Subject: Application No: 2025/44/92737/E - Objection to Planning Application –
Development to the Rear of 23–43 Moor Lane

I would like to register my objection & concerns relating to the proposed development to the rear of 23–43 Moor Lane, on the following grounds.

**Polystorm Attenuation Tank 1**  
**Plan View**  
 (Scale 1:20)

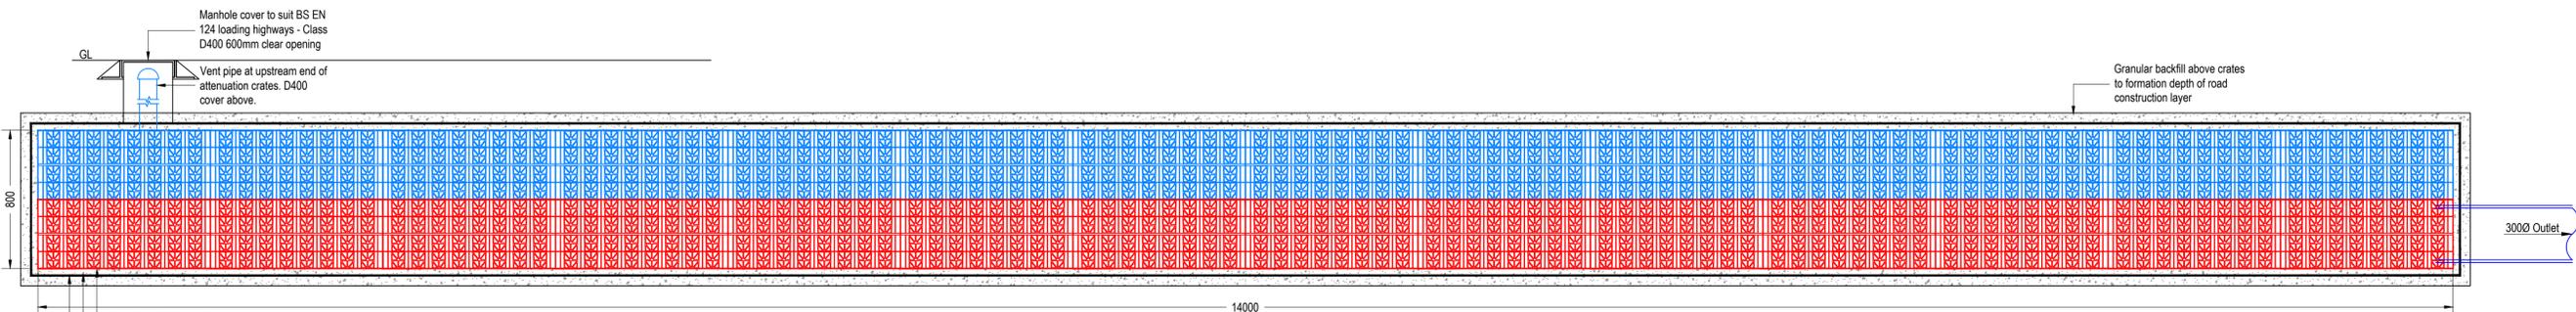
Given the steep gradient of the site, I have serious reservations about whether a crate system is appropriate. From my understanding, such systems perform best in well-draining soils, whereas areas with low soil permeability require an attenuation system with a controlled discharge rather than a simple soakaway. The submitted soil reports indicate that the majority of the site comprises soft

to firm yellow sandy clay and stiff yellow clay below 1.0m, which are known to drain poorly. Based on personal experience of my own garden at the bottom of the site, I question whether this system can operate effectively without increasing the risk of flooding to existing properties, including ours and those of our neighbours at the bottom of the slope.

Although I don't have technical expertise, I find it difficult to understand the need to fill the ground voids identified across the site in the Coal Survey, while also proposing that Plots 9 and 10 be built on raft foundations to accommodate potential ground movement when at the same time, it appears that large excavations will be made directly in front of these plots to install the drainage system. Wouldn't any instability or weakness in the surrounding ground risk causing premature failure of the drainage crates?

Research indicates that crate systems also require accessible inspection points to enable regular maintenance and ensure long-term performance. While this appears to be acknowledged during the construction phase, there is no clear provision for inspection or maintenance beyond completion. If Kirklees Council will not be responsible for the site's ongoing management, could we please have clarification on who will be accountable for maintaining the drainage infrastructure and ensuring its continued adequacy.

**Private Drainage**

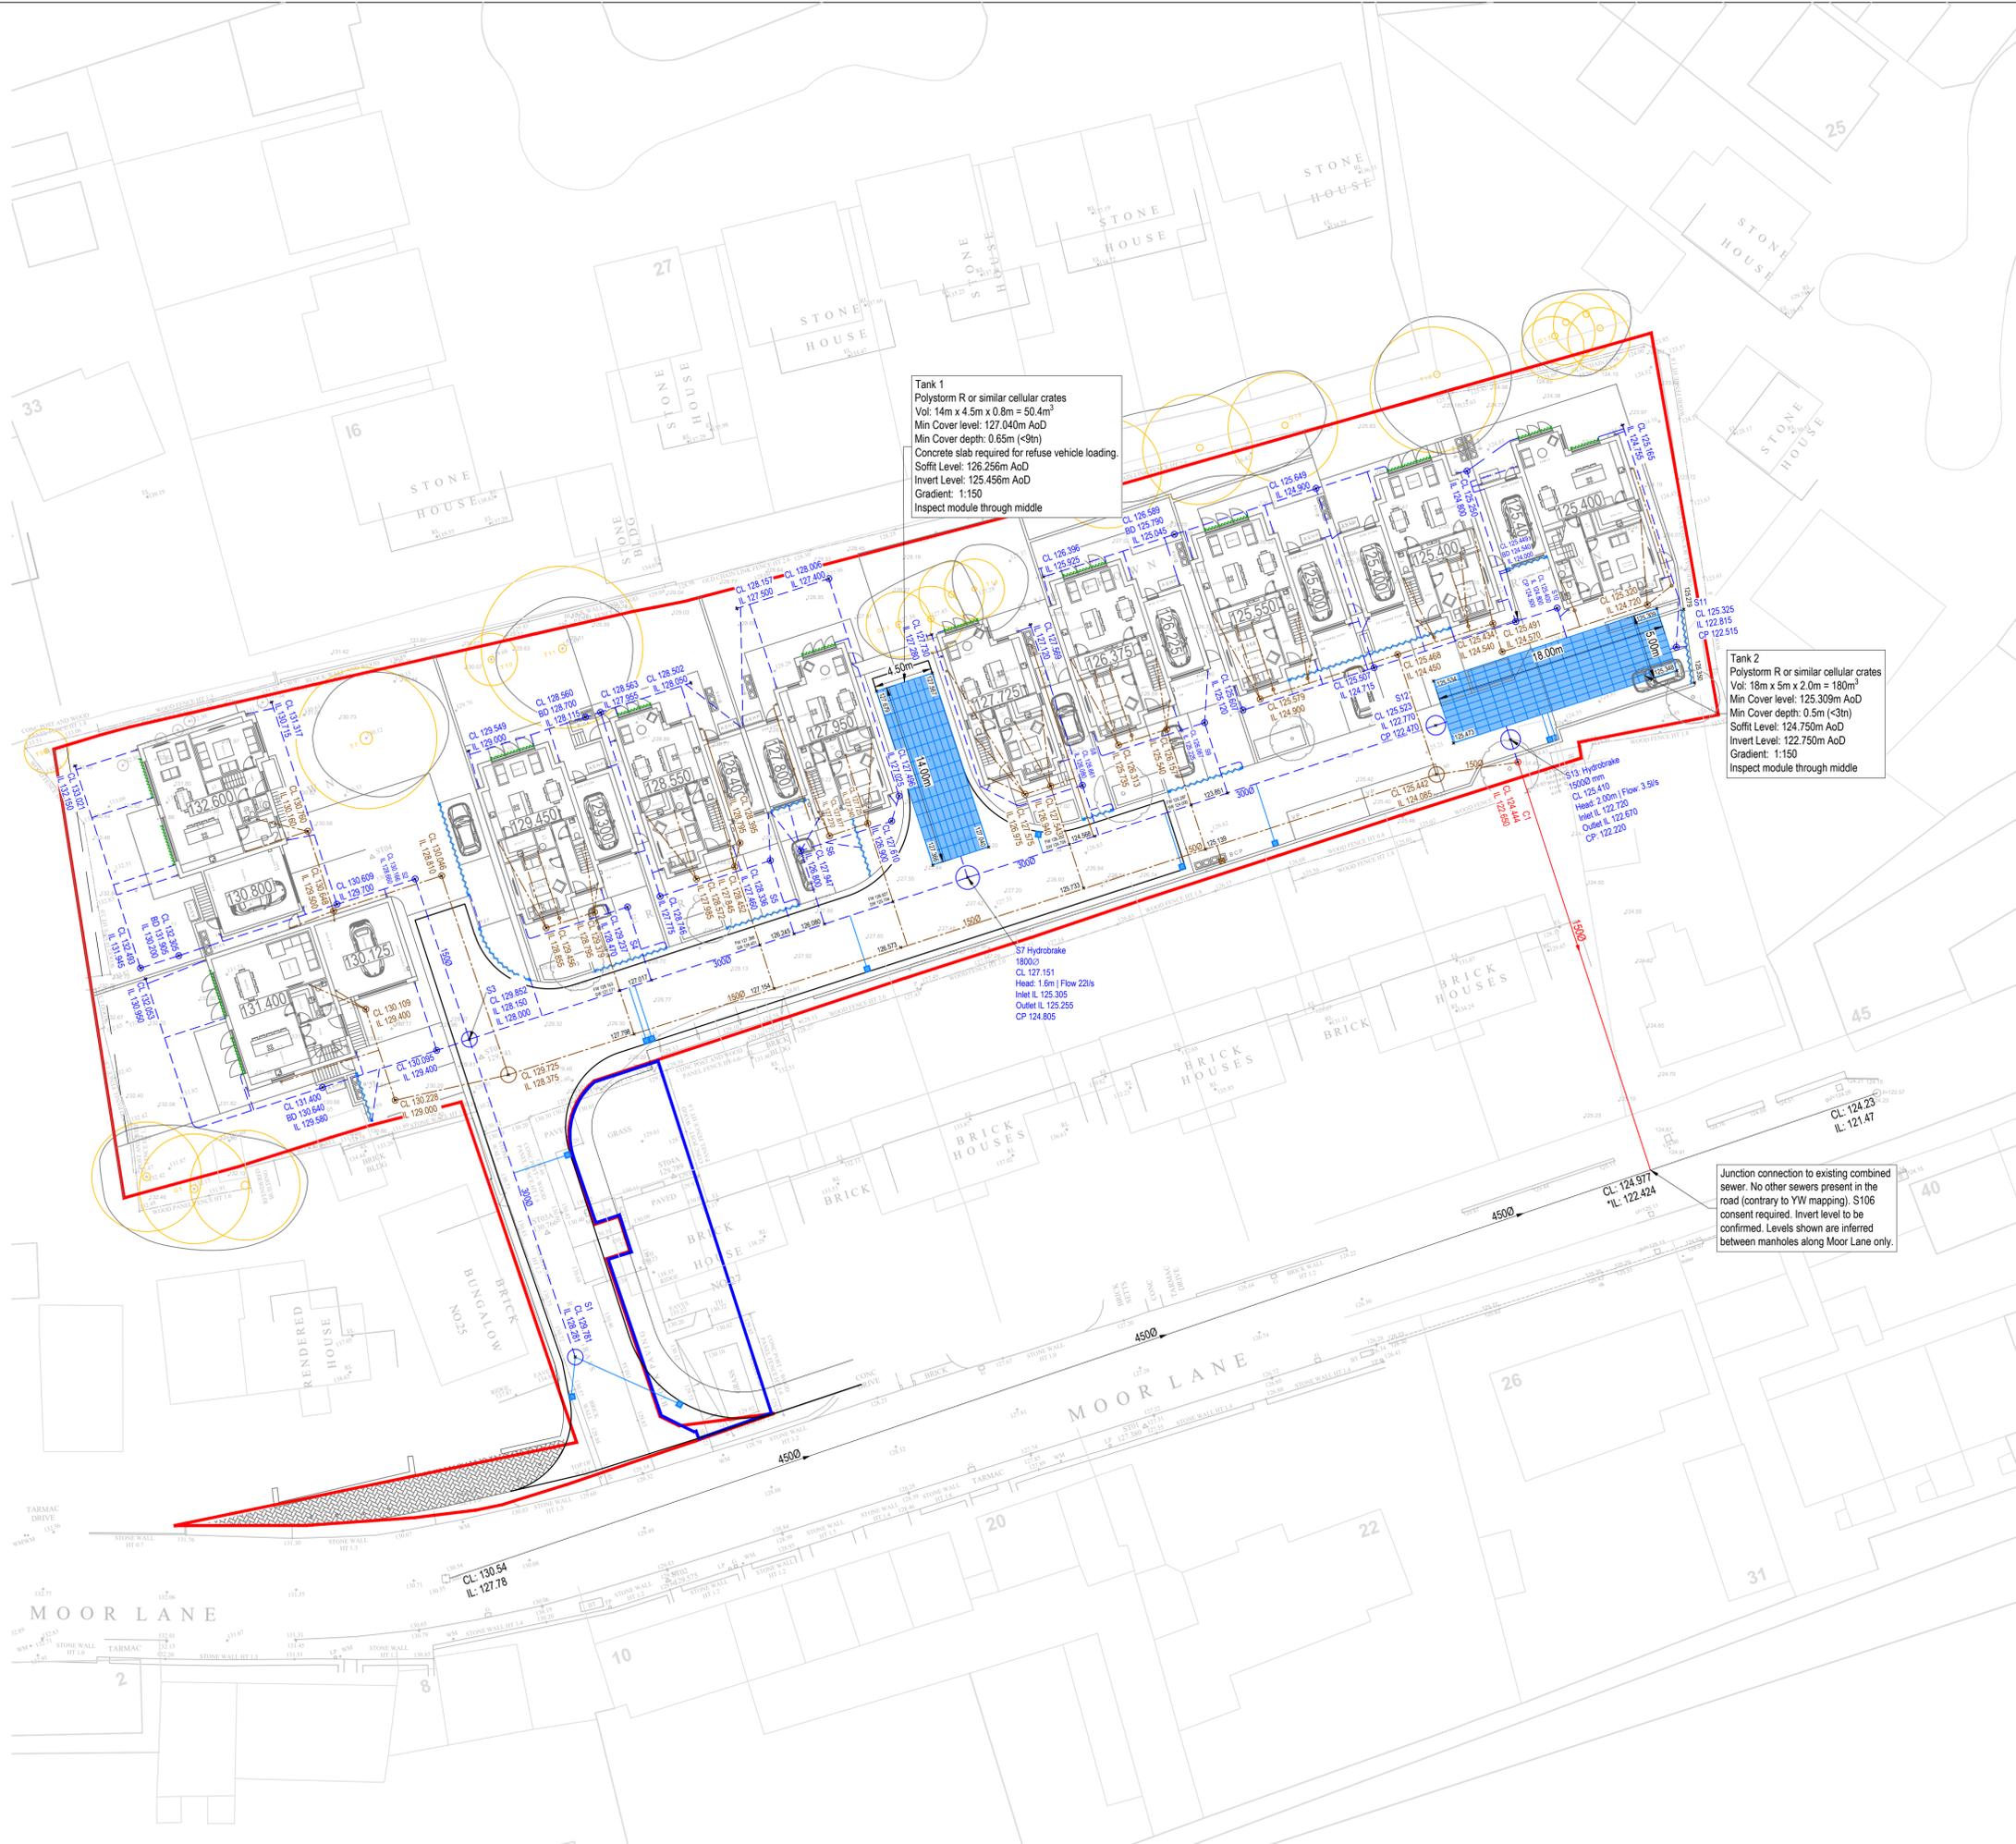
The original scheme proposed two distinct systems, with foul water being pumped back up the site, which was a more robust and appropriate design for this location. Surely combining both systems risks overloading the network, particularly during heavy rainfall?

The proposed drainage levels also appear problematic. The plans indicate a 150mm diameter outfall pipe leading to Moor Lane; however, the garden of 41 Moor Lane already slopes back toward the site, not away from it. This raises questions about whether the gradient is adequate for a gravity-fed system, or whether additional pumping will be required to achieve the necessary flow particularly for what is now proposed to be a combined system.
